**Notification of Modification
Belle O'Connor Street Subdivision (MP 08_0167 MOD 5)**

Thank you for your letter dated 11 April 2018 requesting Transport for NSW (TfNSW) review and comment on the subject Development Modification. Please note that Roads and Maritime Services will provide a separate response.

Figure 4 –Proposed Seniors Living Development Concept

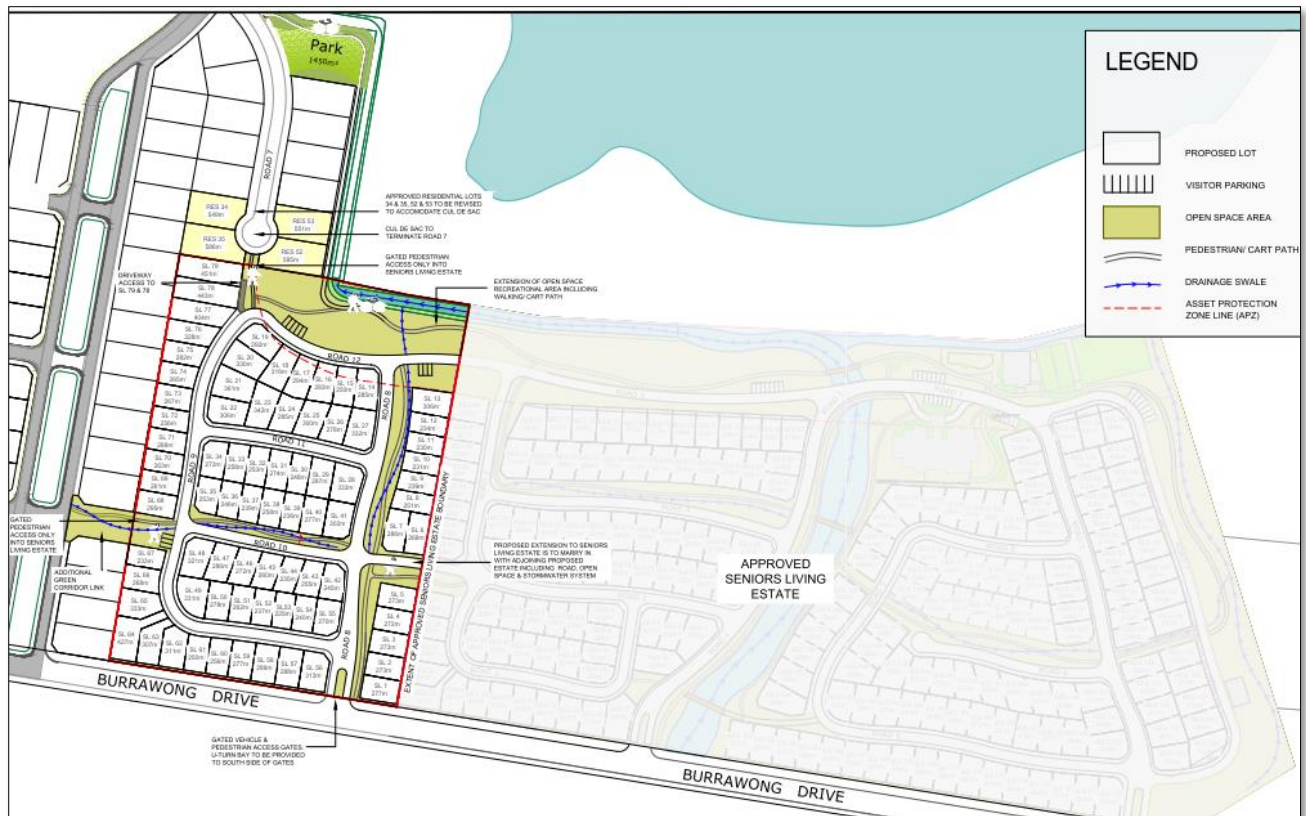
- Future design iterations should illustrate a connected and legible street network that provides direct, safe and convenient pedestrian, cycle and public transport access.

- It is noted that the development will be provide an internal bus service for residents. However, in order to future proof the development site, the internal road design should be configured to enable access for public buses. The minimum requirements include:
 - a 3.5m travel lane
 - a swept path analysis conducted by a 14.5m non rear steer bus
- Any operationally viable bus stop should be DDA compliant.
